Revise/provide Pond Certification Letter with required statements listed in ECM Section 5.10.6.B:

**RE: Forest Lakes Filing 7 - Pond A**

This letter is intended to provide documentation with the County Inspection Staff that the Pond A facility in Forest Lakes Filing 7 has been constructed per design. Classic Consulting has reviewed the final constructed facility and recently gathered survey as-builts confirming the appropriate size and design. Based upon this information and information gathered during periodic site visits to the project during construction, Classic Consulting is of the opinion that this stormwater BMP has been constructed in general compliance with the approved construction plans and specifications as filed with El Paso County.

**AS-BUILTS POND 'A'  
FOREST LAKES FILING 7  
SF-21-49**

**8'X4' OUTLET BOX ORIFICE PLATE**  
SCALE 1" = 2'

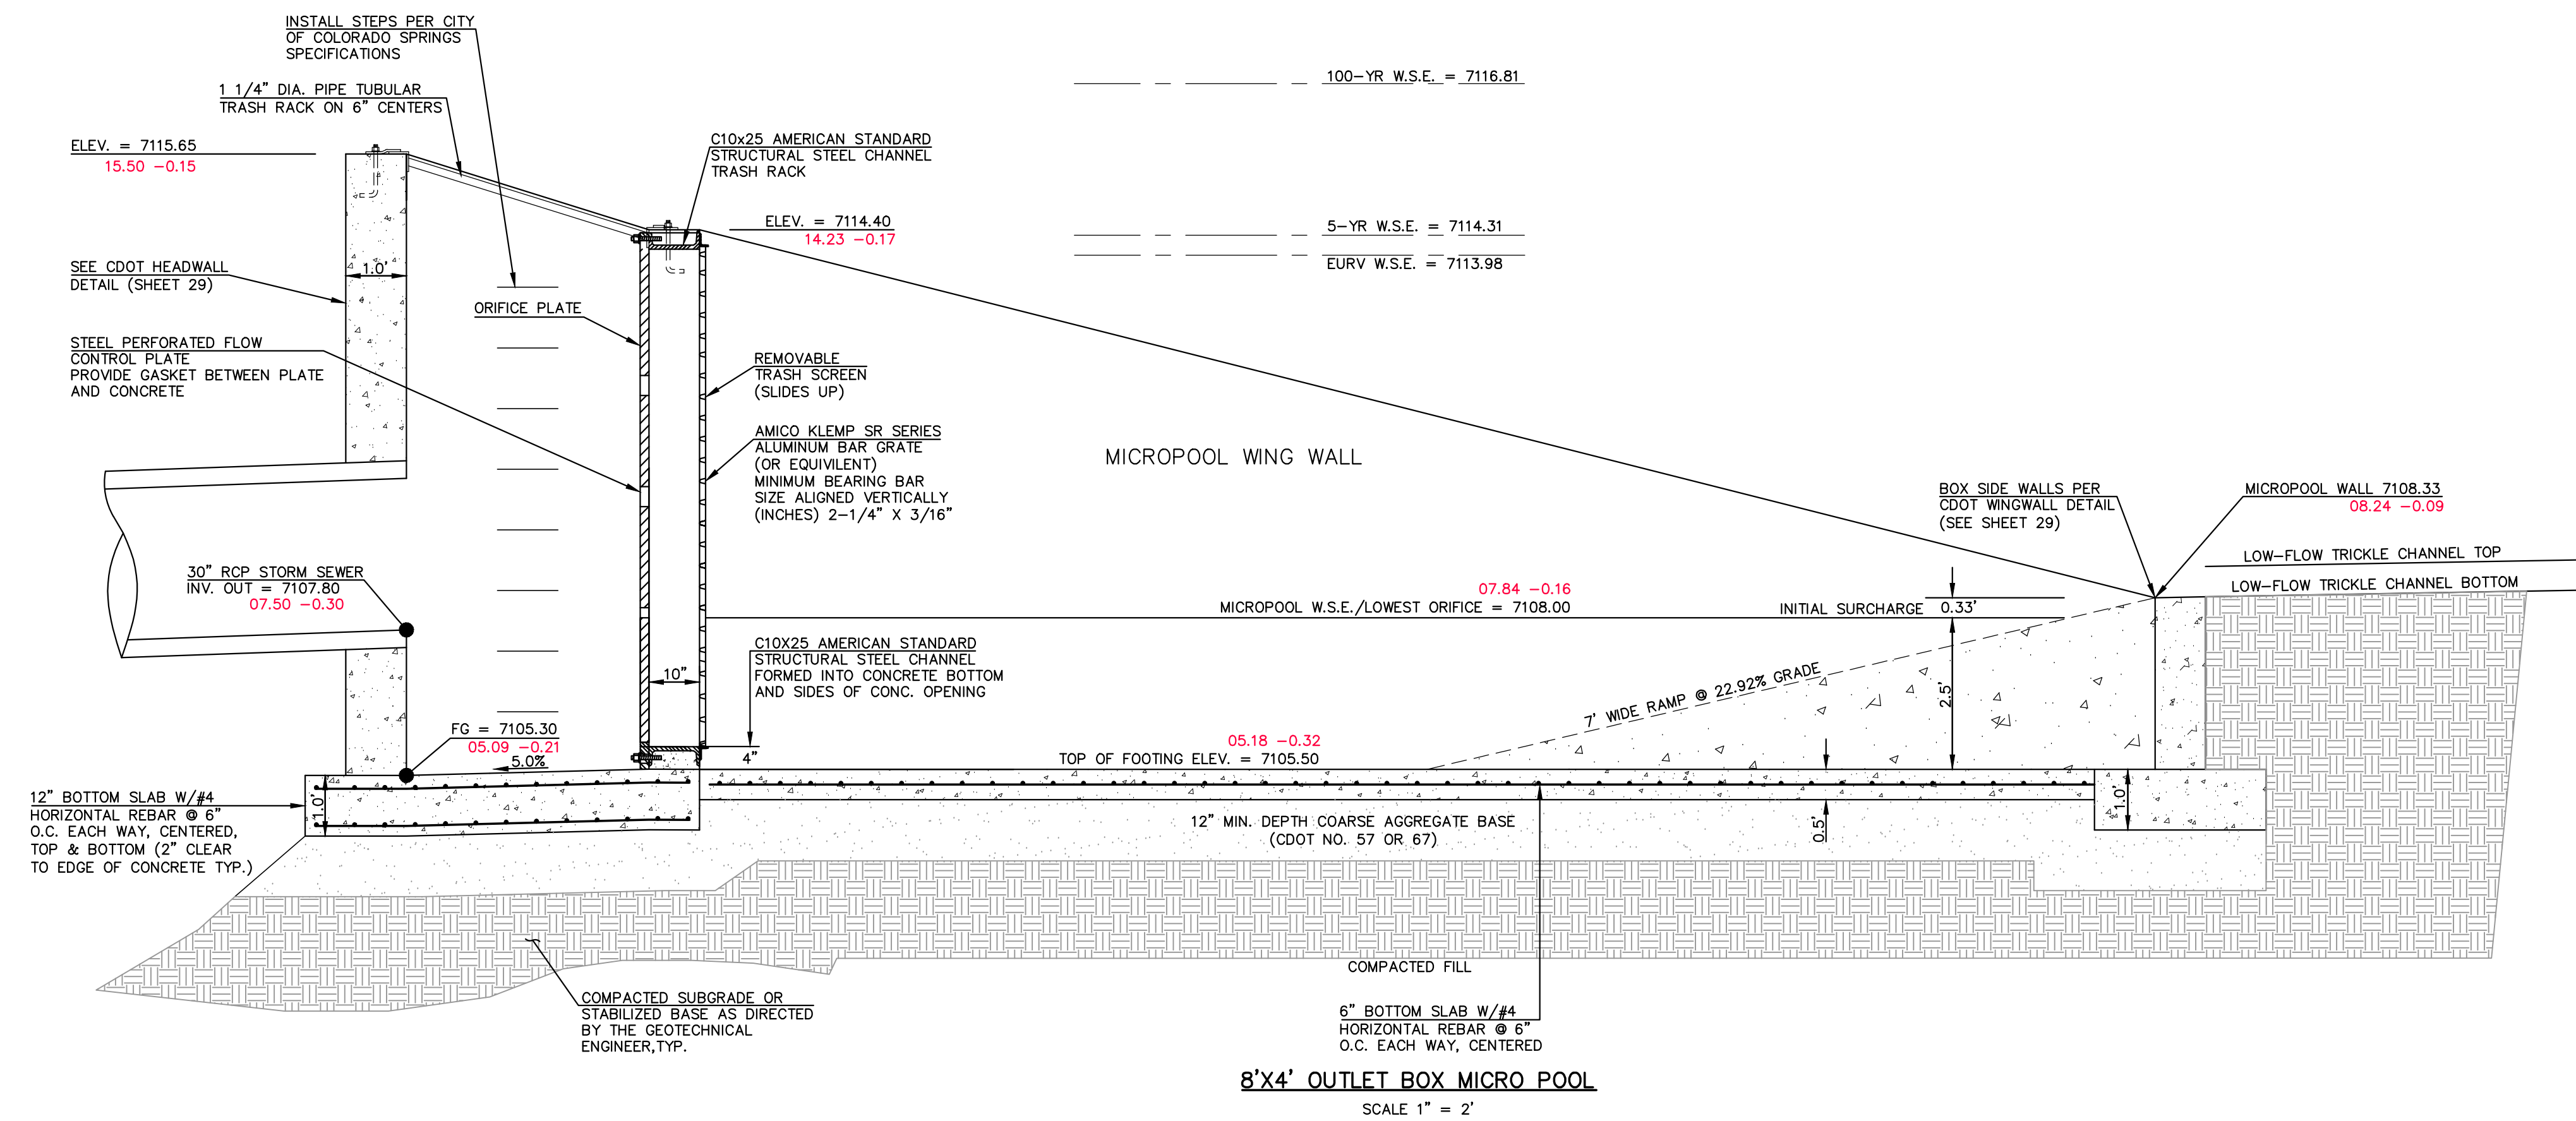
This was 2.13 & 4.27. Why was it changed? Per Sht 25 of the as-builts, all 3 orifice were installed 0.16 lower than the original design so this spacing would not be different.

This was 6.40, but Sht 25 of as-builts shows that it was installed 0.17ft lower, which would be 6.23. However, this input is supposed to be relative to Stage=0ft, which is the top of micropool, which was installed 0.16 lower than design. So the differential for this value should actually be -0.01 or at 6.39ft above Stage=0ft.

For similar reasons as above, this is actually 9.07 (micropool went down 0.16 and spillway only went down 0.09, for a total difference of +0.07)
